DECISION DELEGATED TO HEAD OF PLANNING

Application No: H02-0212-26 **Applicant:** Mr G Luparia
Proposal: Erection of new 3 bedroom dwelling
Location: Adjacent To 77 Peterborough Road Crowland Peterborough
Terminal Date: 29th April 2026

Indicative House Type - 3 Bedroom House

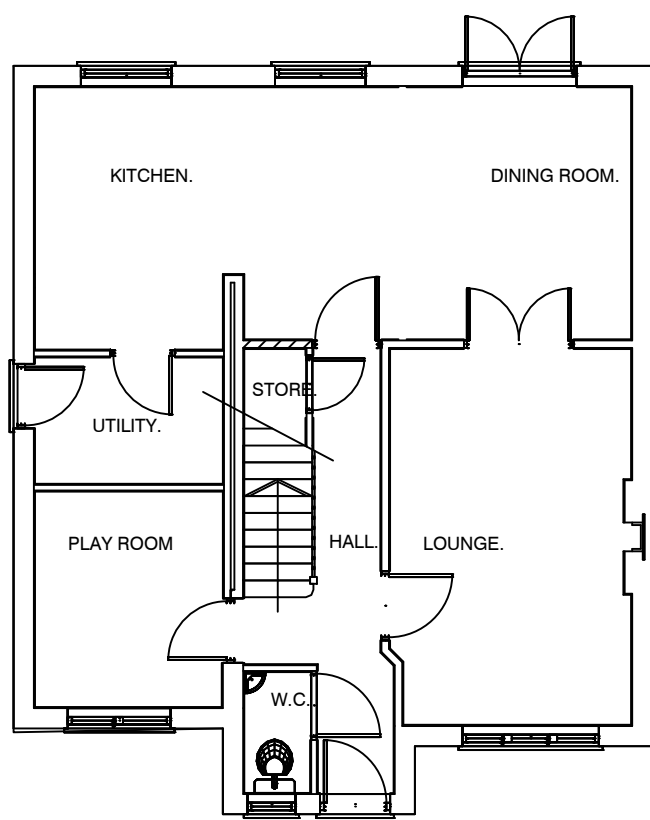
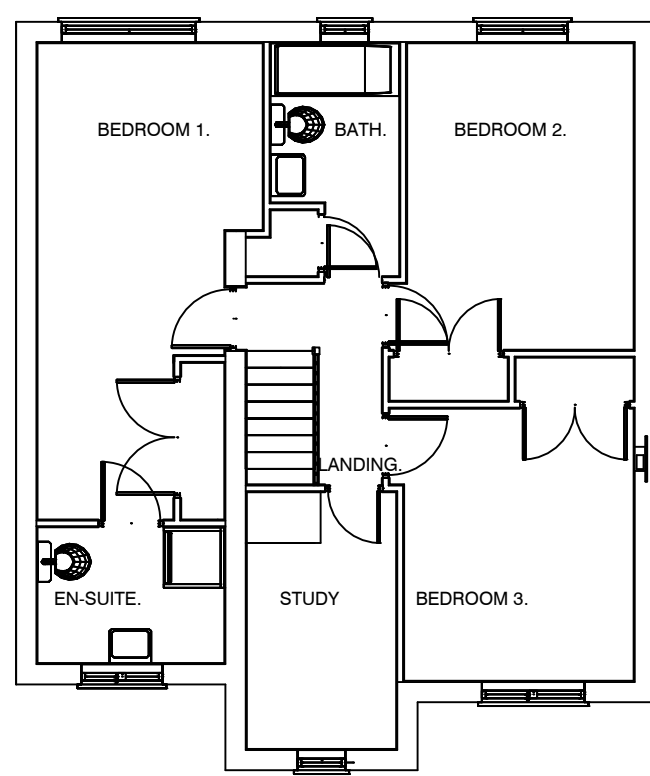
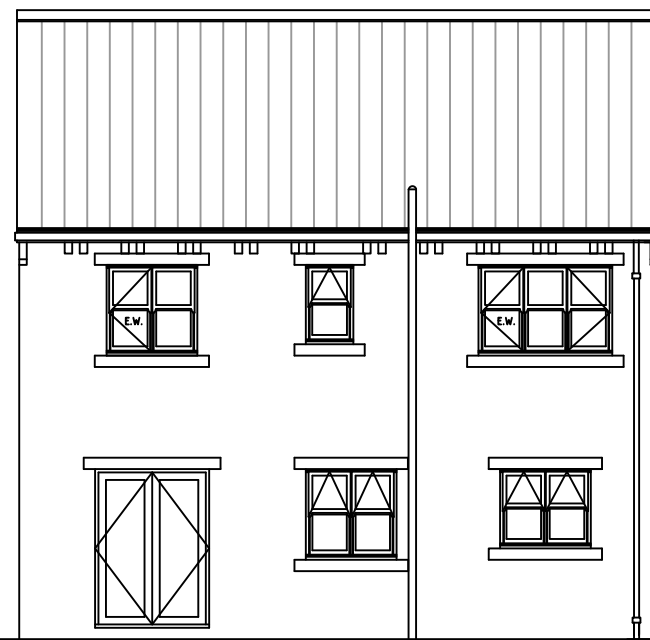
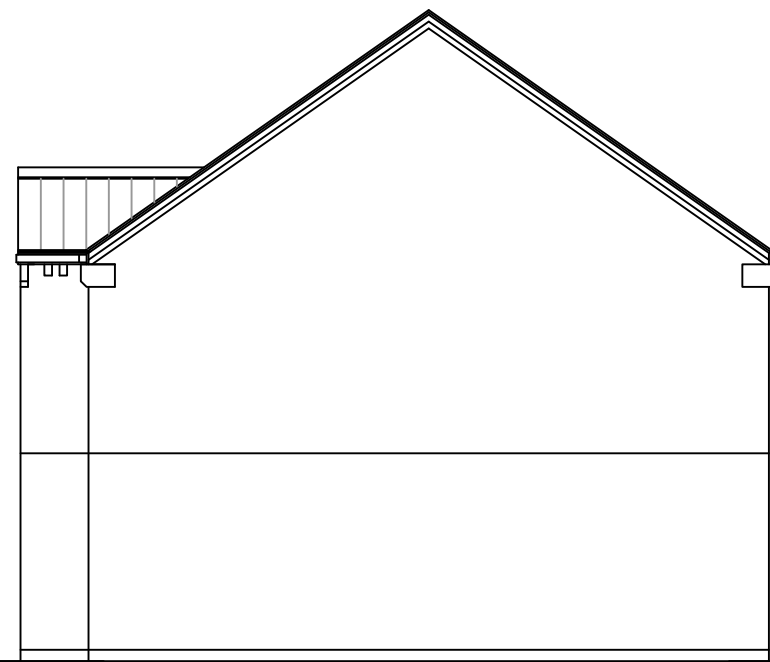
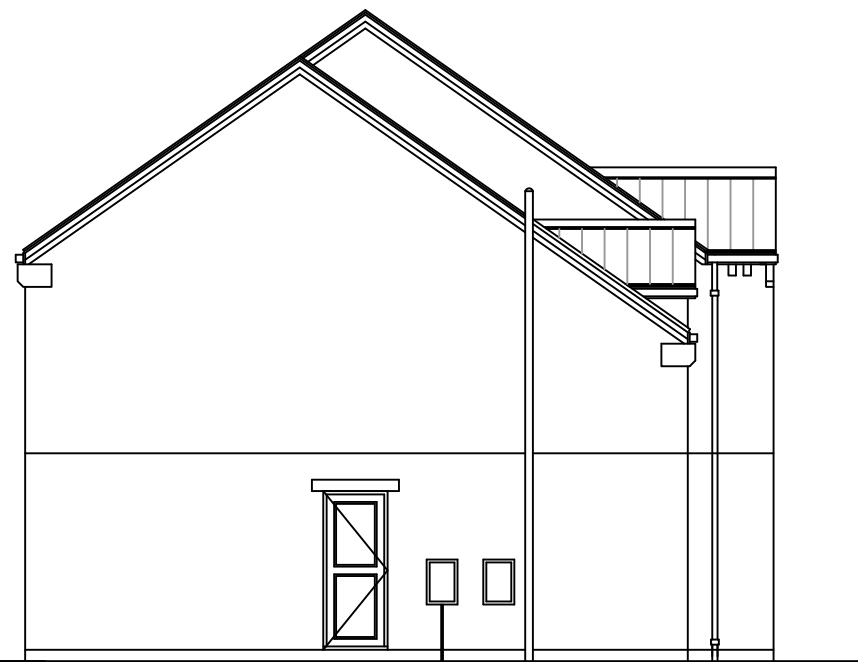
At this stage, the proposed scale, appearance and layout of the dwelling is unknown. As such, it is difficult to assess the visual impact of the proposals. Notwithstanding this, the application is accompanied by an indicative site layout plan which shows how a dwelling could be positioned within the site. The indicative layout shows how the dwelling could be set back from the road frontage by approximately 16m, slightly further back than No.77 to the south. An appropriately sized dwelling, garden and front driveway would be provided based on the indicative layout.

Given the plot size it is expected that the dwelling frontage will face eastwards toward Peterborough Road. Any first-floor rear elevation windows would face towards the detached garage and frontage driveway of 1a Harvester Way. It is considered that there would be suitable separation distances between the rear elevation of any dwelling within the site and the nearest dwellings to the west of the site.

It is noted that concerns have been raised within the public representation that has been received regarding the potential for overshadowing of 1a Harvester Way. 1a is a 1.5 storey bungalow located to the west of the site. It is unlikely that the proposed dwelling would result in an unacceptable loss of daylight to 1a Harvester Way due to its likely position within the site. For example, the dwelling is likely to contain a rear garden that is of a similar depth to 77 Peterborough Road which will reduce the potential for overshadowing as the dwelling would not be directly adjacent to the dwelling within the plot of 1a Harvester Way.

PROPOSED SITE PLAN 1:200

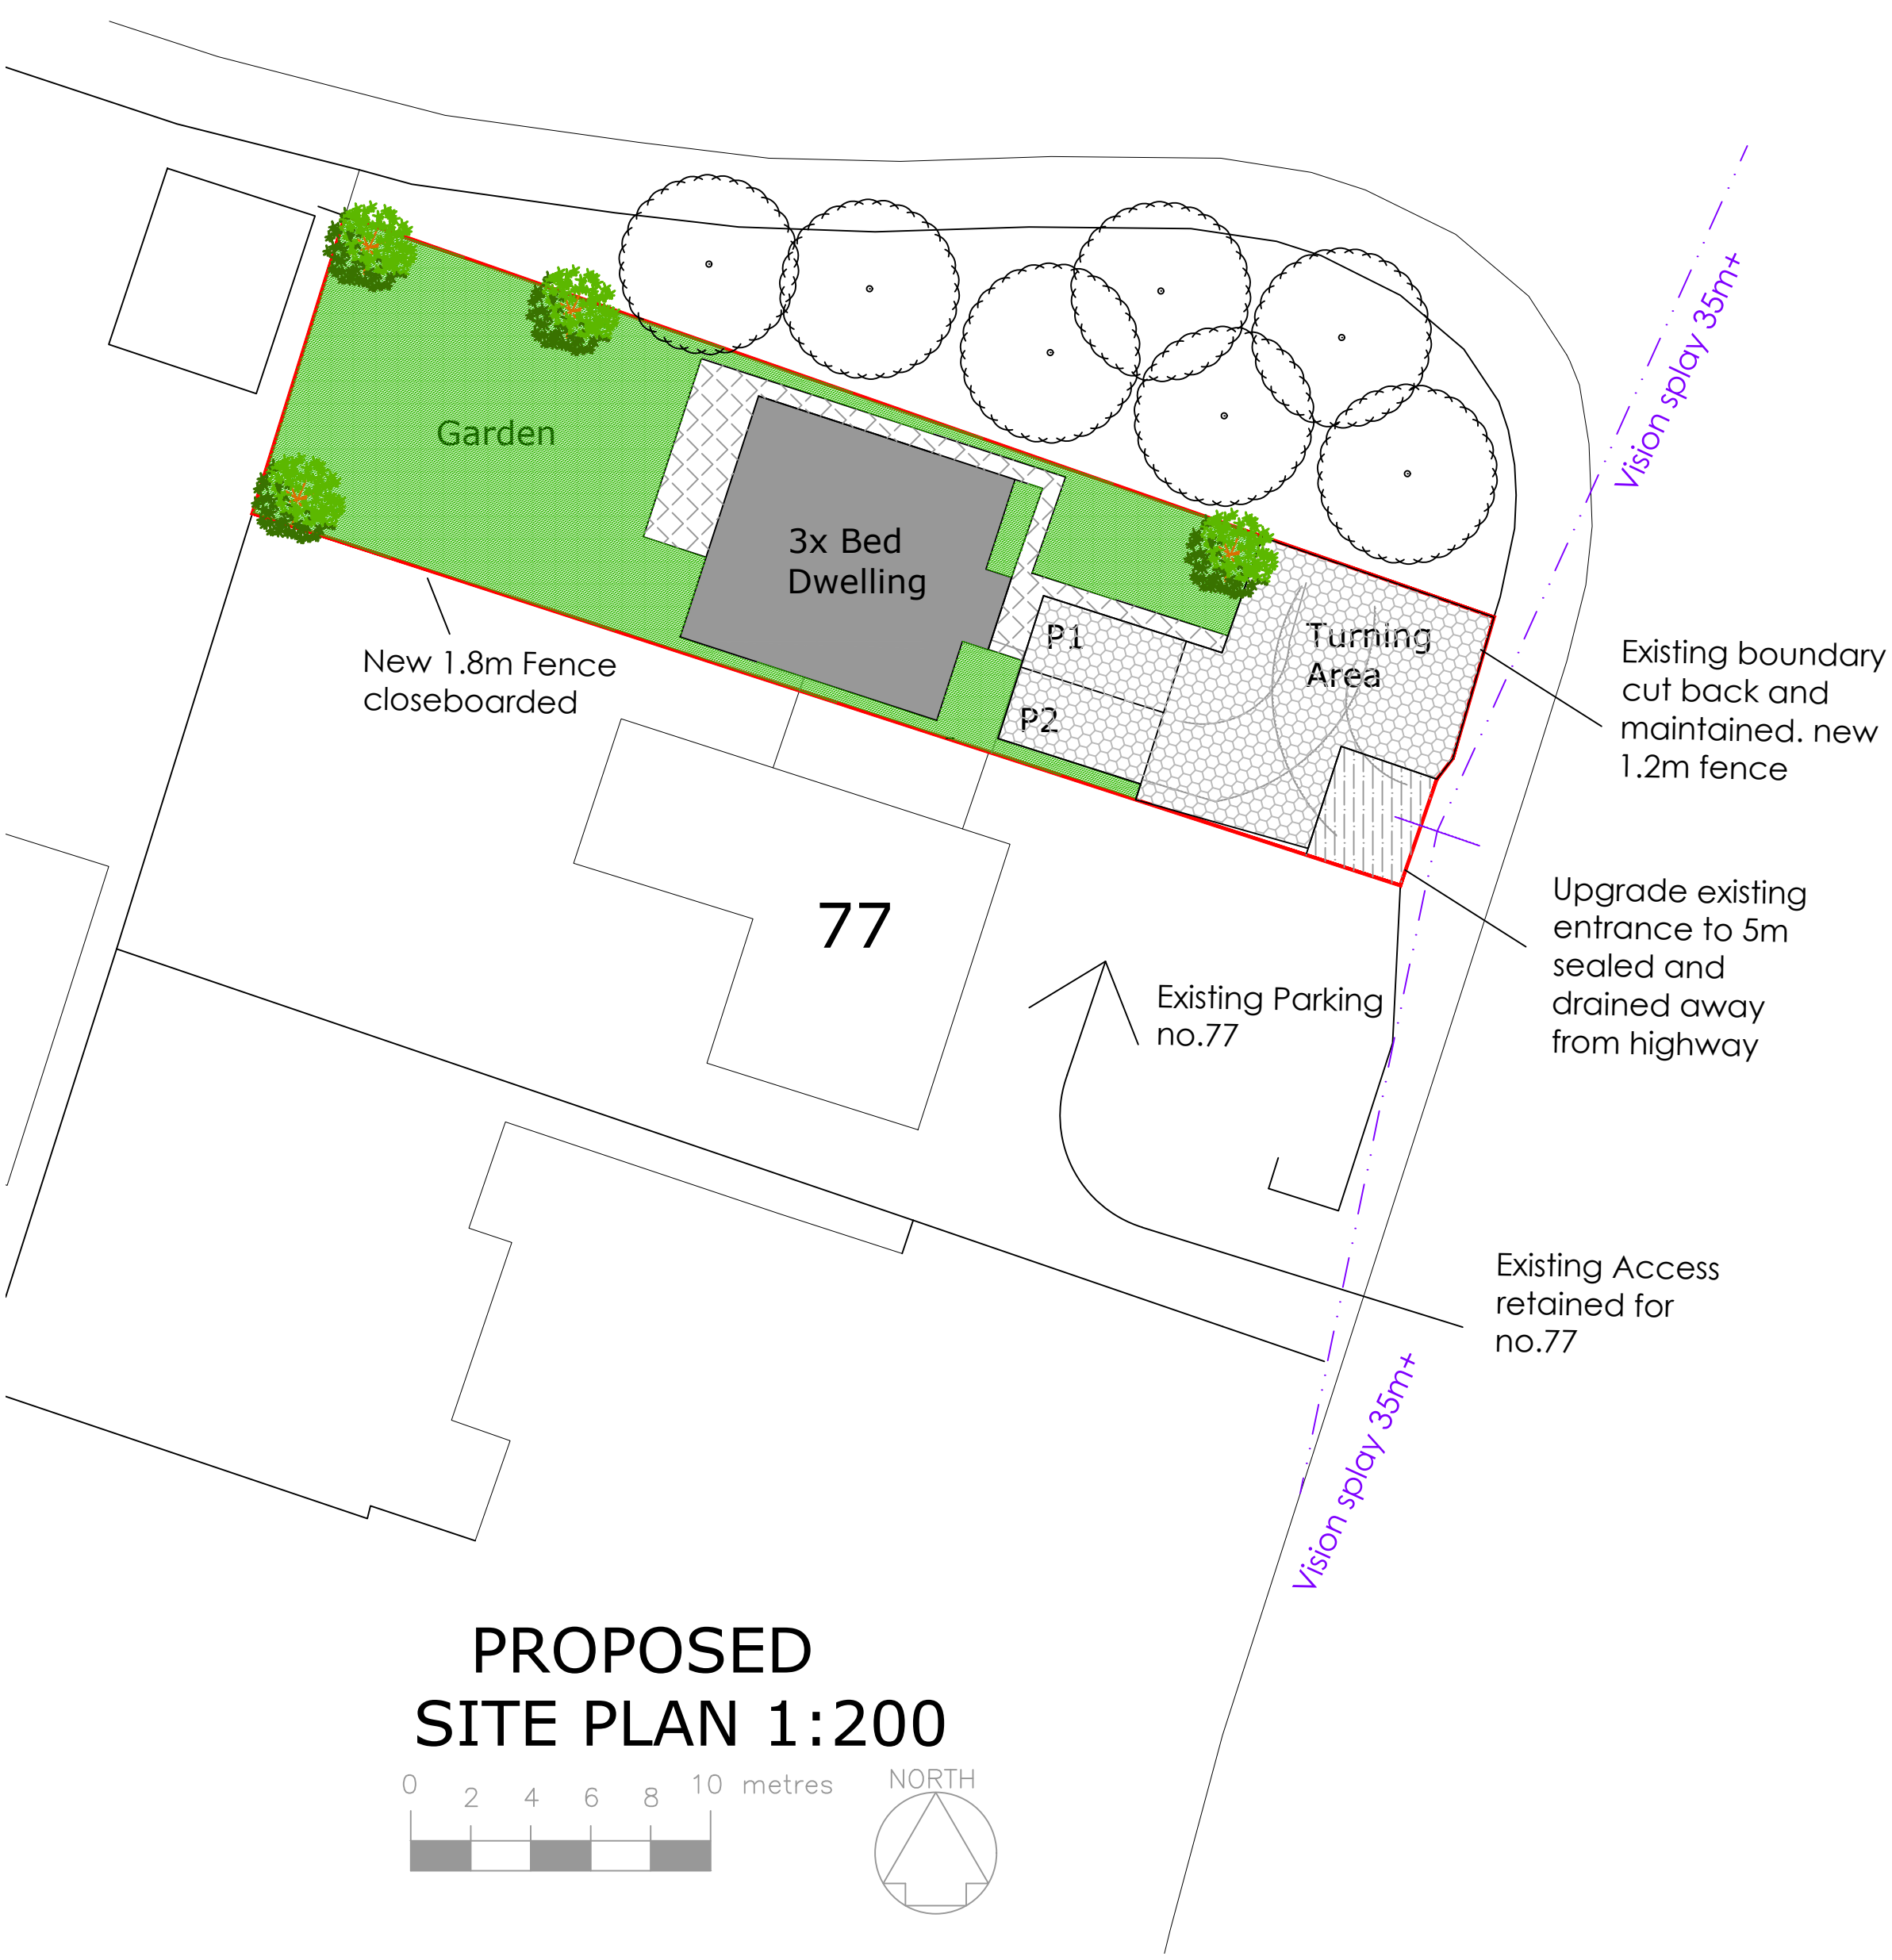
Lincolnshire County Council - Highways and SUDS: The minimum width of an access is 2.5m why is 5m proposed? Will the access be just for the proposed dwelling? Will a boundary treatment separate the host and the proposed dwelling? If any alterations are proposed a note should be added to the proposed site plan to say that it will be done to Lincolnshire County Council Specification. It is noted that the two access points to the existing dwelling are already in place, as the proposed dwelling will increase vehicle movements in/out of the access it would be advised that the height of the front boundary hedge is reduced to 1m in height to improve the visibility.

Lincolnshire County Council's Highways Team have raised some queries with the proposals. For example, the team have queried why the access is proposed to be 5m wide when the minimum requirement is 2.5m. The team have queried whether a boundary treatment will separate the dwelling and 77 Peterborough Road. Lastly, the Highways Team have recommended that the height of the front boundary hedge is reduced to 1m in height to improve visibility splays from the site. The front boundary hedge is outside the red line boundary and it is not considered necessary to require this to be reduced in height as part of the current proposals. Whilst the access is relatively wide, this does not mean that the access is unsuitable. The access is already in place with a dropped kerb from Peterborough Road. Further details of the proposed boundary treatments can be secured at the reserved matters stage as the landscaping of the site needs to be confirmed as part of any reserved matters application.
